SSD-48225958 – Gundry Solar Farm – Windellama Road, Gundry – EIS response

Transport for NSW (TfNSW) is responding to the Environmental Impact Statement (EIS) for SSD-48225958 – Gundry Solar Farm, exhibited from 15 November 2024.

TfNSW has reviewed the EIS prepared by Umwelt dated 14 October 2024 and Appendix 14 – Transport Impact Assessment (TIA) Prepared by The Transport Planning Partnership (TTPP) dated 1 August 2024 as key documents for preparing this response.

DWG No.	23042CAD003		
	FIGURE 7		
DATE STAMP	19 JULY 2024		
PROJECT No.	SCALE	REV.	
23042	1:500 @A3	A

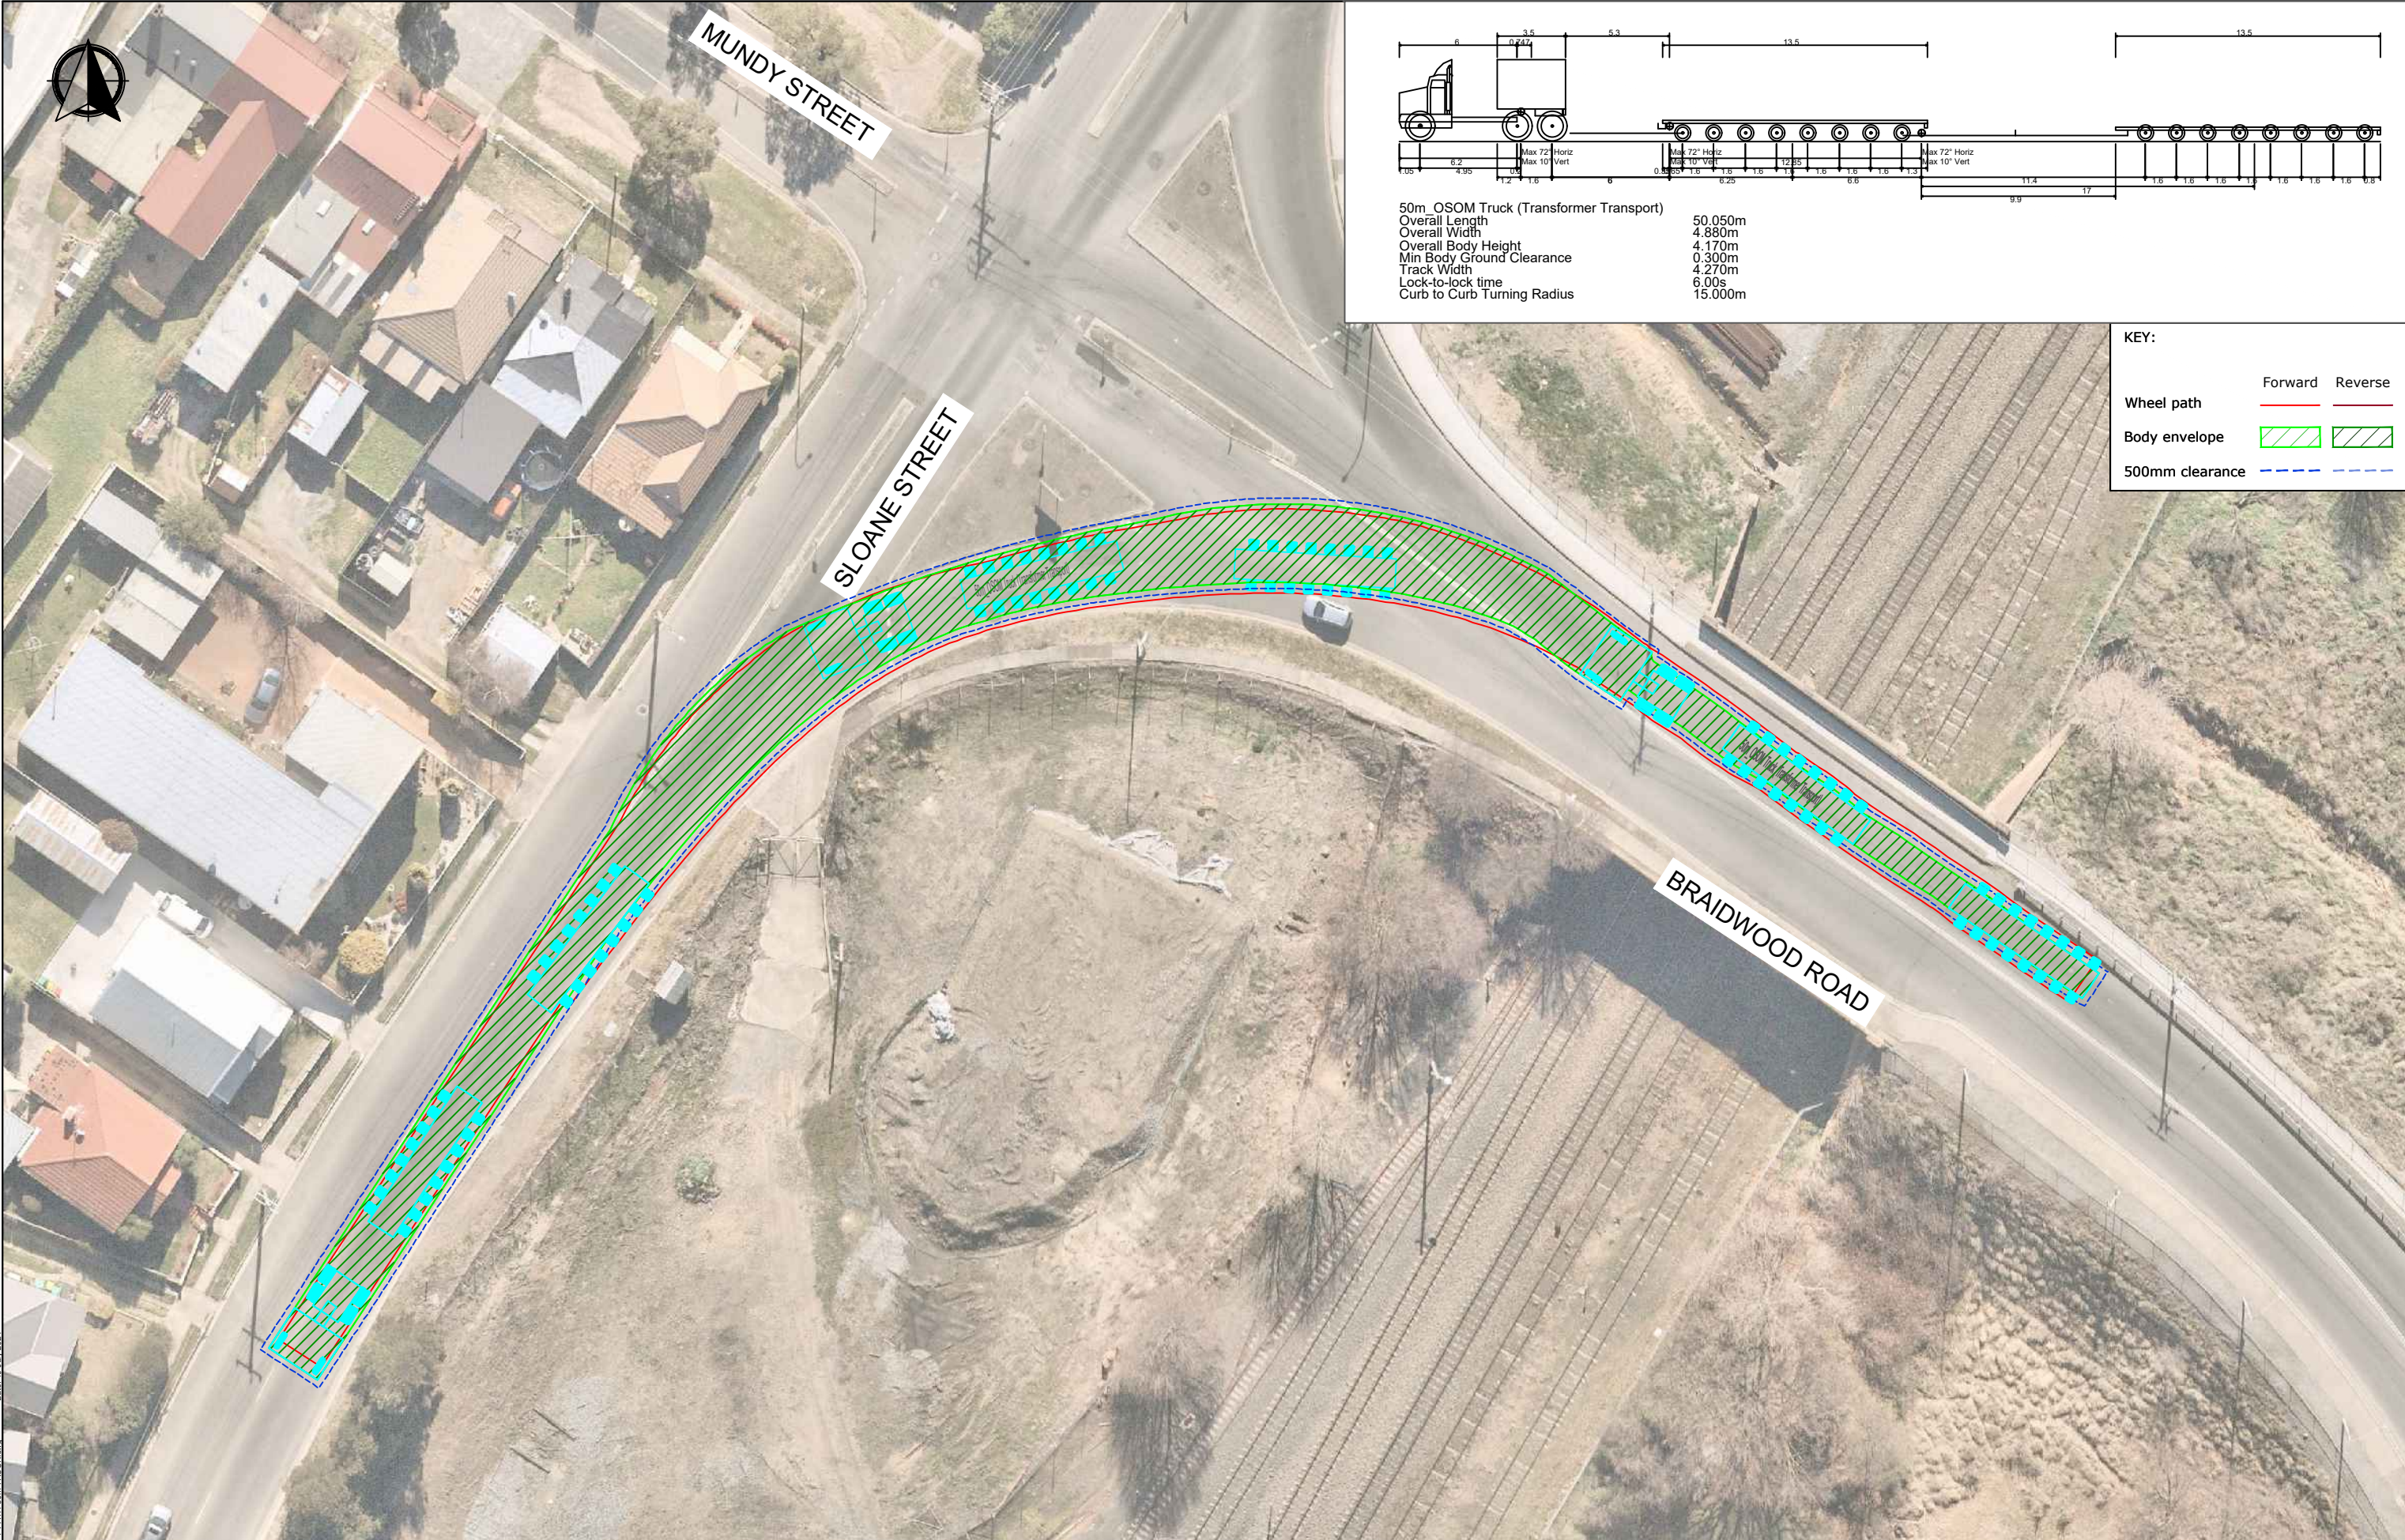
- d) The TIA is required to include details of all high-risk OSOM loads and vehicle configurations for the project.
 - e) Swept path analysis for the largest high-risk OSOM vehicles demonstrating that the largest high-risk OSOM vehicle can physically enter, exit and park without impacting travel lanes and that sufficient parking and access will be provided to other vehicle types permitted to access the identified rest area or pullover locations.

- g) Swept path analysis for the largest and longest high-risk OSOM navigating each pinch point or intersection along the state road network.
 - h) Identify each at-risk road structure that the high-risk OSOM route crosses, traffic signals, signage, powerlines, bridges (including height clearances to overpasses and trusses), major culverts, and minor culverts that may not meet the desirable cover to cater for proposed axle loads.
